**KIRKLEES METROPOLITAN COUNCIL
INVESTMENT & REGENERATION SERVICE**

**DELEGATED DECISION TO DETERMINE APPLICATIONS FOR
CONSENT, AGREEMENT OR APPROVAL REQUIRED BY CONDITION**

Reference No:	2024/44/90237/W
Site Address:	adjacent, Britannia Road, Golcar, Huddersfield, HD3 4QB
Description:	Discharge of conditions 3 (construction environmental management plan), 4 (public right of way), 5 (retaining walls), 6 (Phase II Report), 7 (Remediation Strategy), 9 (Remediation Validation Report) and 18 (Japanese Knotweed) of previous permission 2021/92062 for erection of 9 dwellings and associated works
Recommending Officer:	Katie Chew

Second Officer Report

SITE SECTION 1 SCALE 1:100
section details taken from structural engineers drawing 5879-101 and AIP as agreed with highways dept.

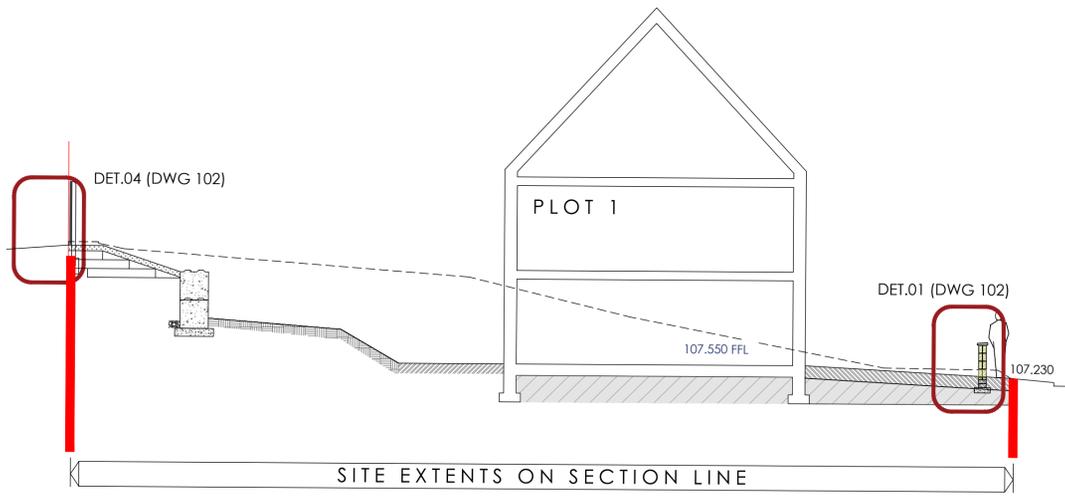
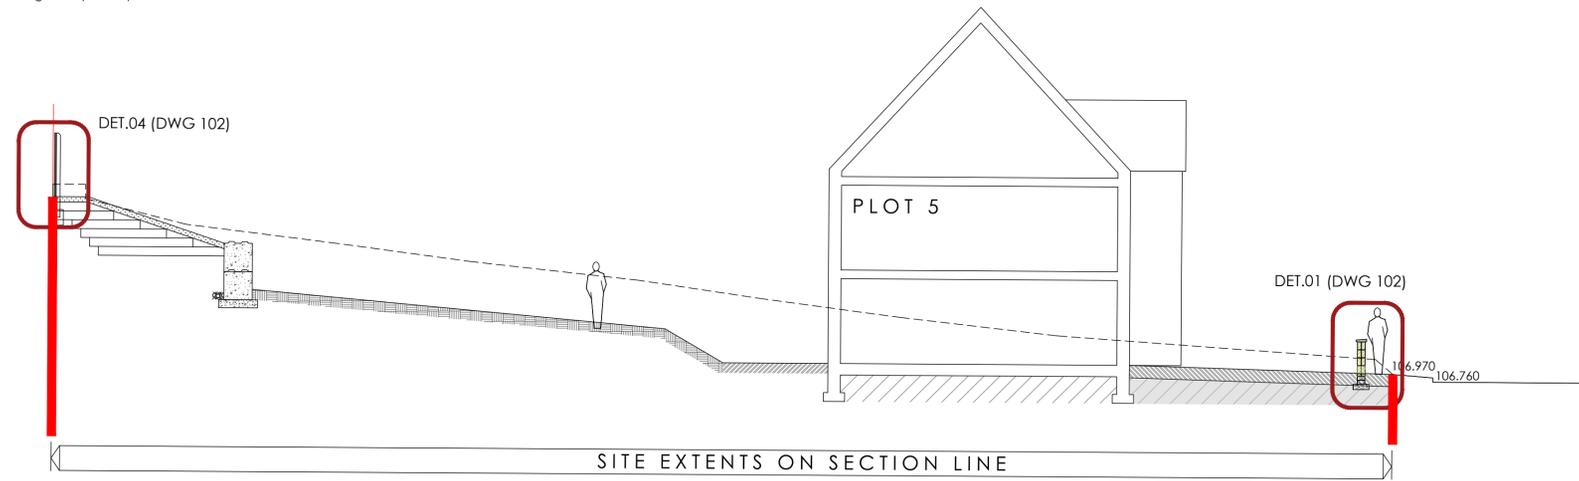
I would like to advise that condition 5 (retaining structures) cannot be discharged pending the submission of a fully dimensioned X-sectional detail along the eastern boundary of the site adjacent to PROW (Ref HD/451/10) (based on max retained height) to determine whether the proposed retaining structure will be liable to a formal technical approval (via submission of an AIP). The sectional detail will need to include the full width of the private access road and the exact location and width of the PROW that runs along it.

Following receipt of the above comments, the applicant sought to submit revised plans and an Approval in Principle. KC Highway Structures reviewed this updated information and confirmed within their response dated 20/11/2025, that the submitted details were acceptable to discharge Condition 5. However, they do note that the applicant will need to submit a “Construction Compliance Certificate” together with “As Built” drawings for the gravity burr walls upon the completion of the works, to conclude the technical approval process in accordance with CG 300- Technical Approval of Highway Structures. Such an additional requirement would fall outside the scope of this discharge of conditions application, however, a note reminding the applicant of their obligations regarding completion of the AIP process is recommended.
